Medworth Energy from Waste Combined Heat and Power Facility

PINS ref. EN010110
Document Reference: Vol 9.20
Revision: 7.0
Deadline 7
August 2023

Schedule of Changes (Deadline 7)

**Figure 10.1i**  
**New Bridge Lane access design**

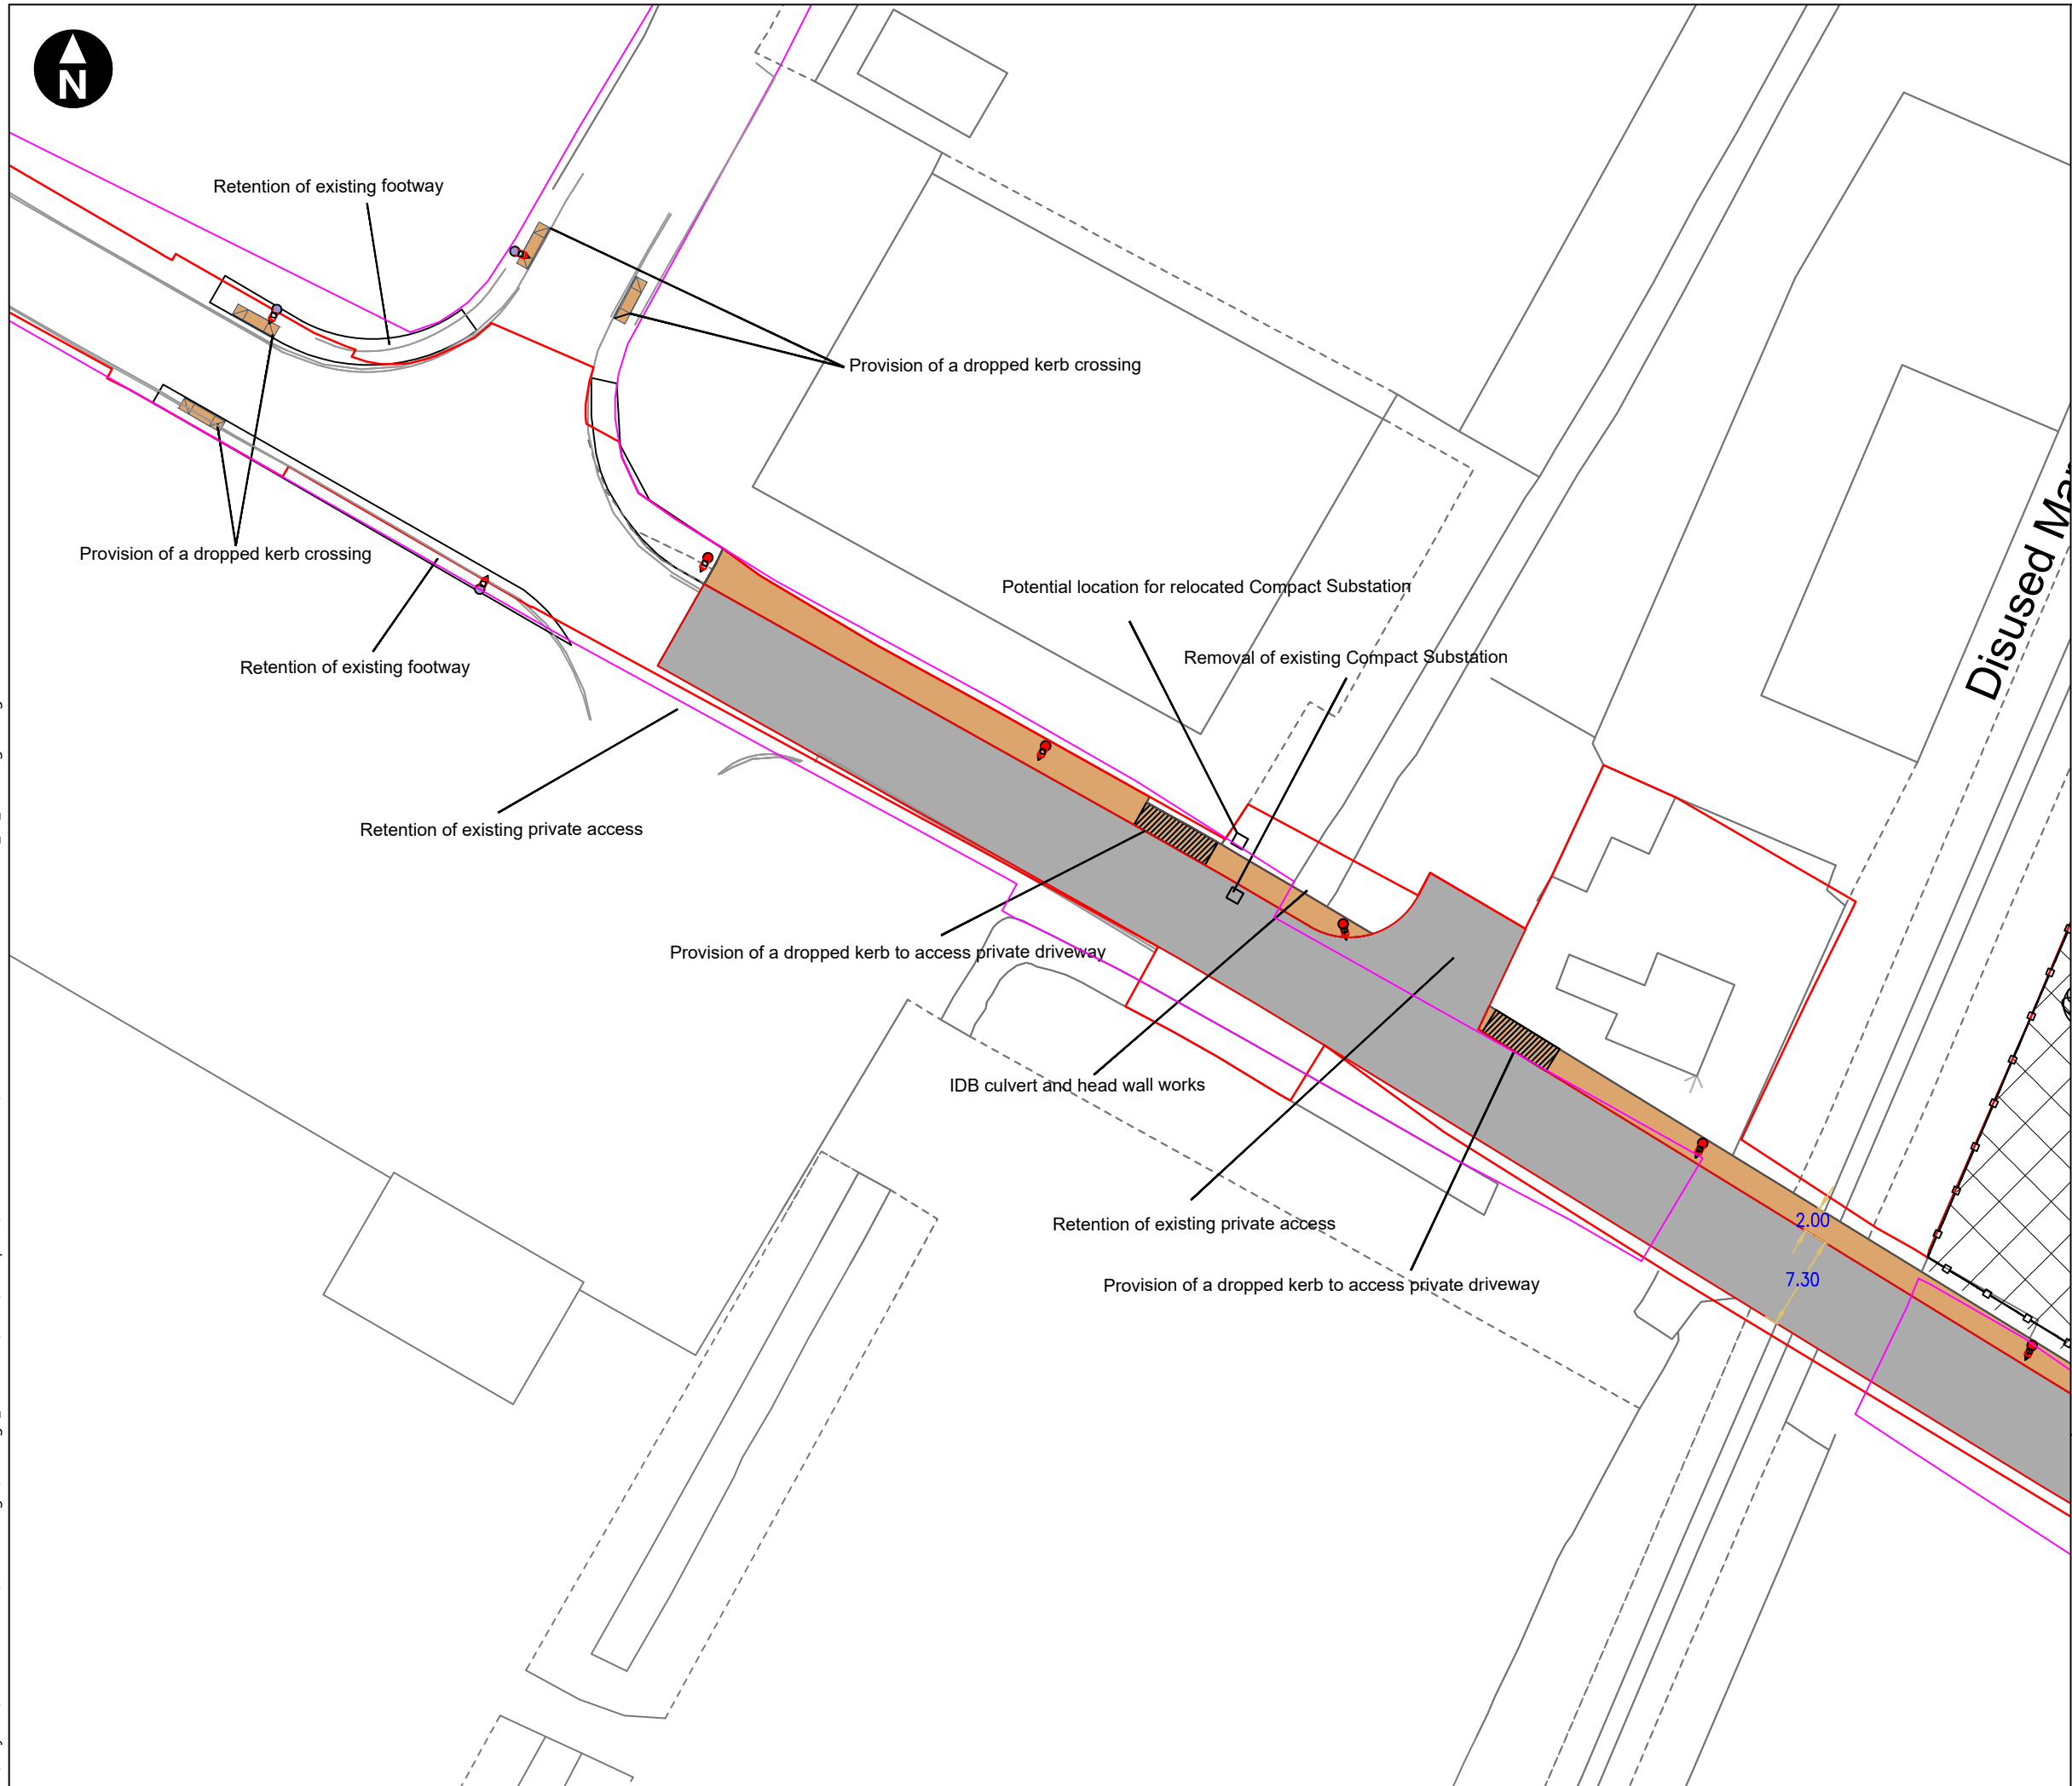
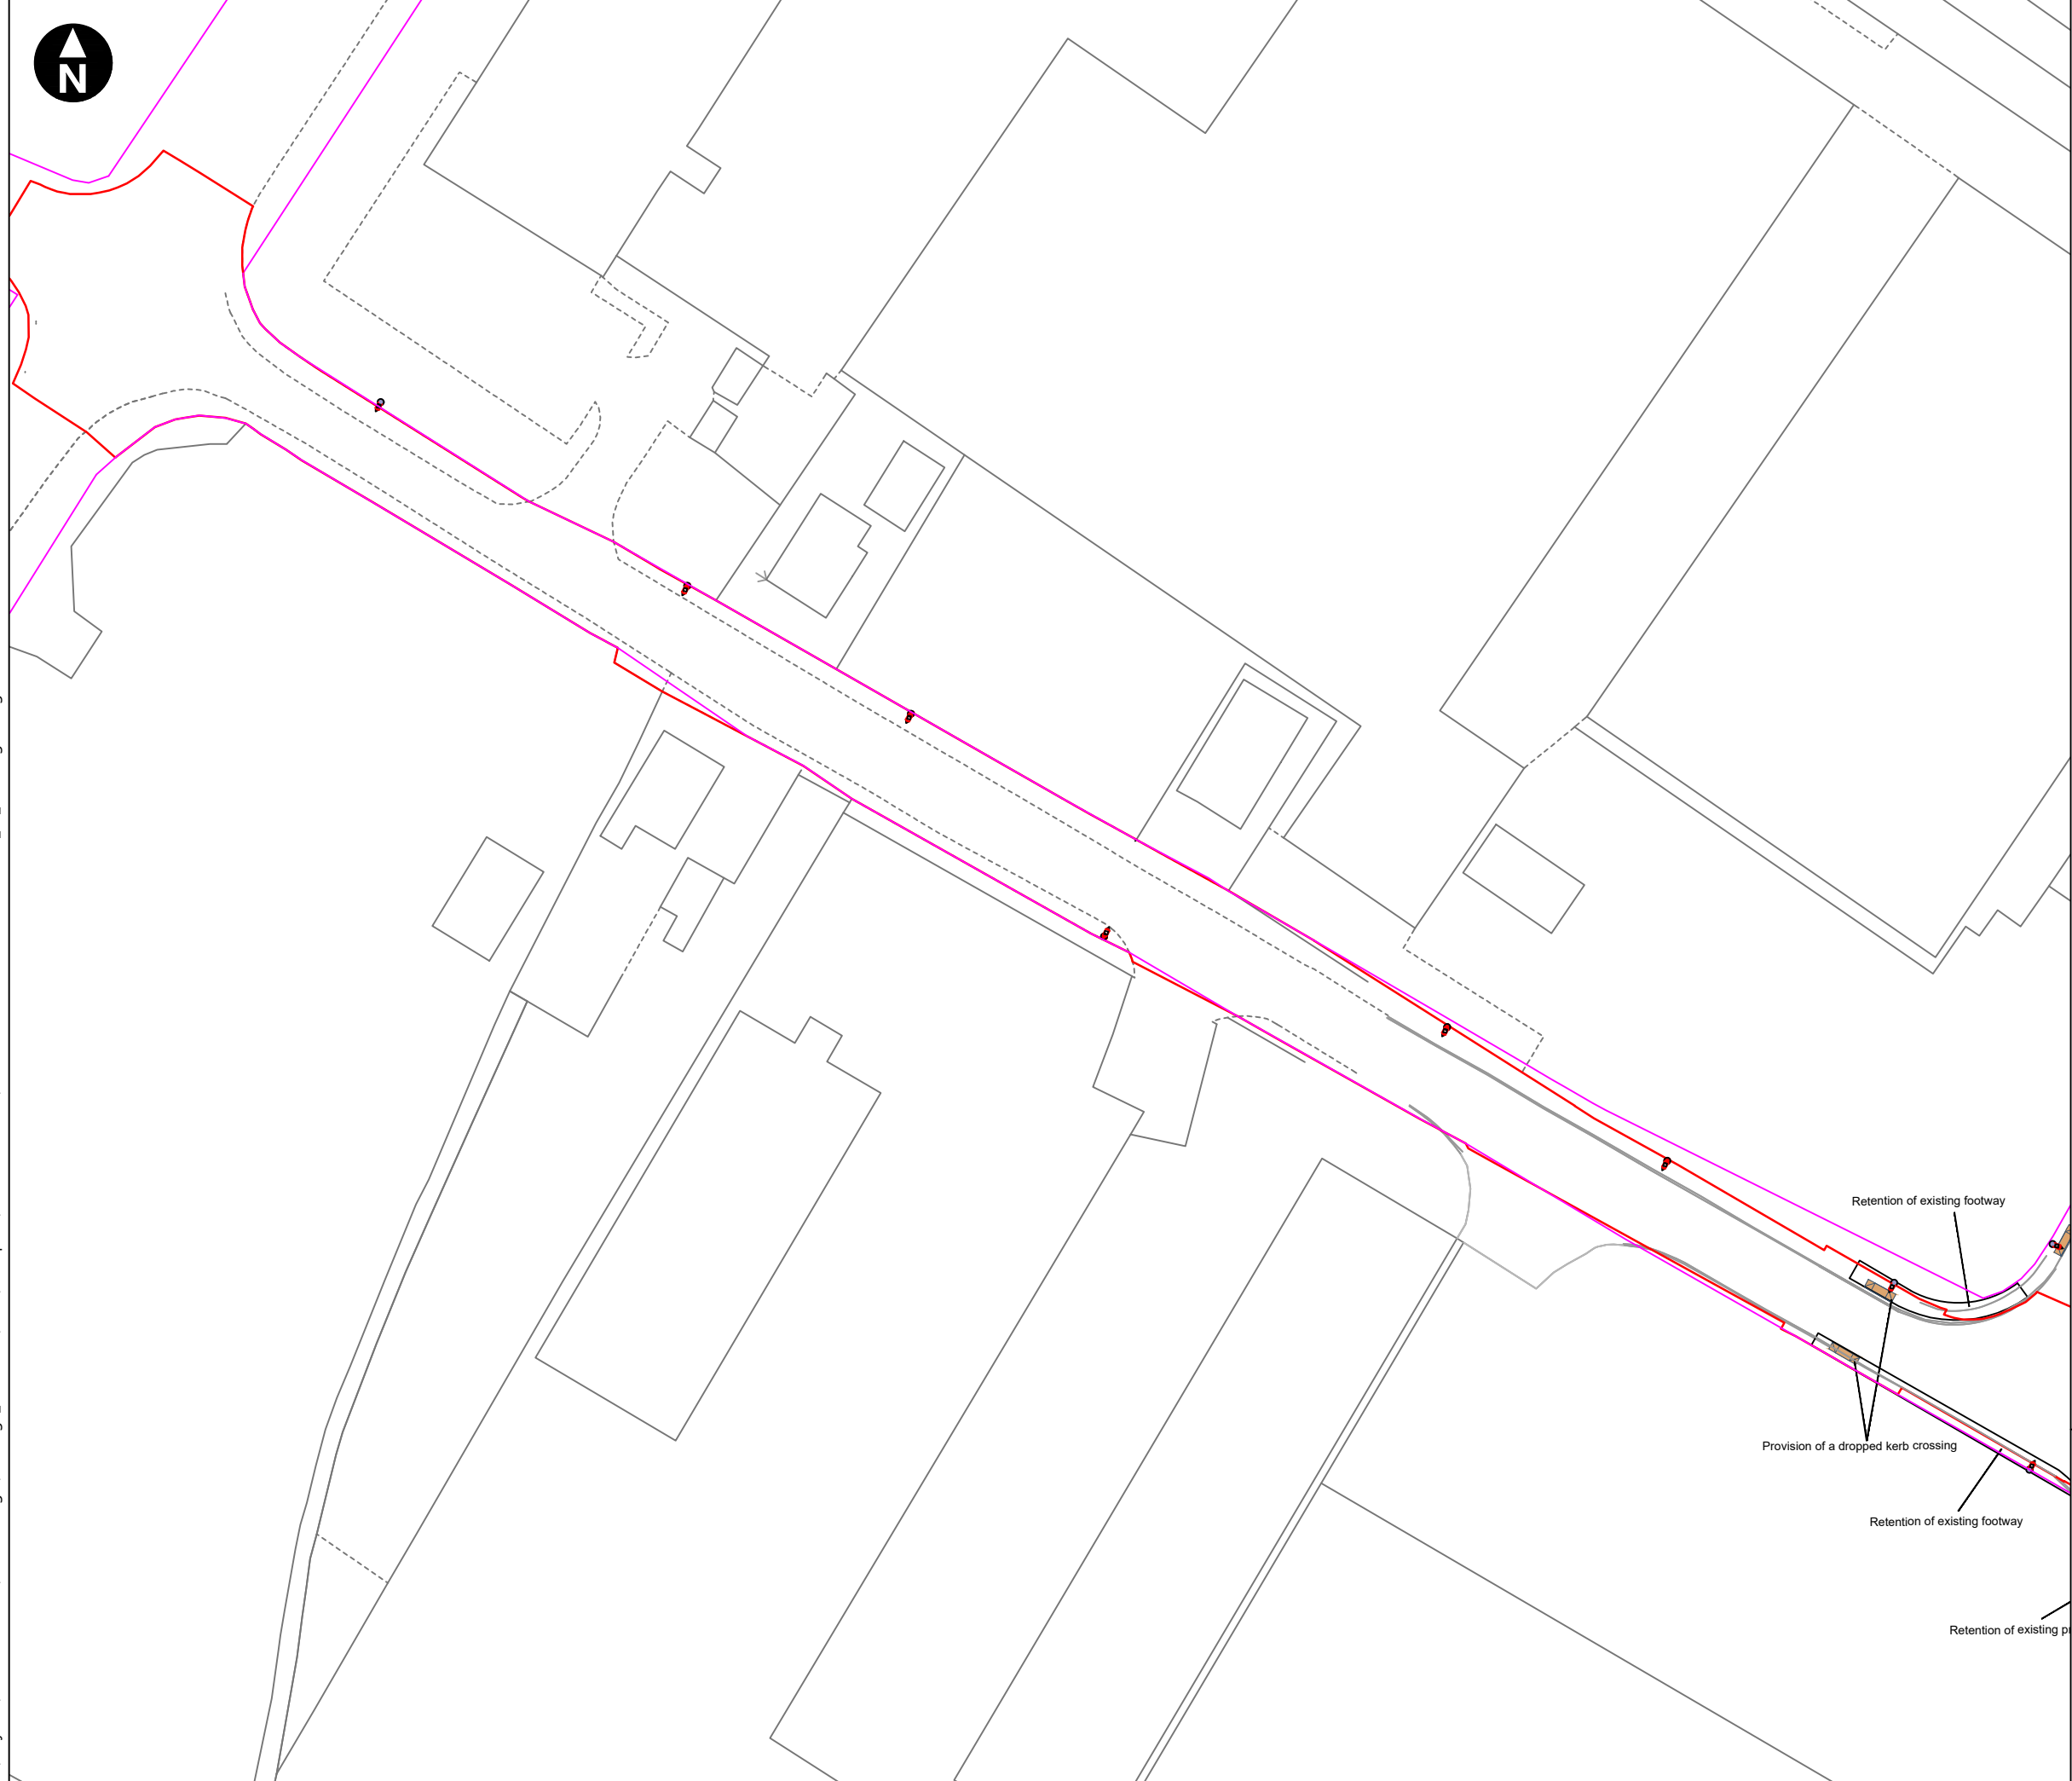
Volume 6.4 ES Chapter 6 Traffic	Additional drawings, Figures 9.2ii to show swept path of vehicle leaving New Bridge	CCC and FDC LIR paragraph 2.7.32 and 2.7.34 [REP1-074] .	Deadline 3	Rev 3

Document Updated	Change	Reason for change	Deadline submitted	Relevant Document version
and Transport Appendix 6A Outline (CTMP) [REP1-011]	Lane. Also Figure 10.3i – ii to show outline design for construction accesses into the CHP Connection Corridor from Weasenham Lane and accompanying swept path.			
Volume 6.4 ES Chapter 7 Noise and Vibration Appendix 7D Outline Operational NMP [REP1-012]	Reference to Applicant's intention to purchase 9 New Bridge Lane updated to confirm that the property has been purchased. Additional text added to 5.1.2 to include for the submission of a report to the relevant planning authority detailing the height, materials and acoustic performance of the acoustic fence to 10 New Bridge Lane for agreement ahead of construction.	CCC and FDC Comments on the Applicant's D1 Submissions (Outline CEMP) [REP2-031]. Outline Operational Noise Management Plan.	Deadline 3	Rev 3
Volume 6.4 ES Chapter 7 Noise and Vibration Appendix 7D Outline Operational NMP [REP1-012]	New paragraphs 1.4.8 and 1.4.9 to provide a commitment to the preparation of an Operational Noise and Vibration Management Plan for the Walsoken Substation.	KLWN Relevant Representation [REP2-028].	Deadline 3	Rev 3
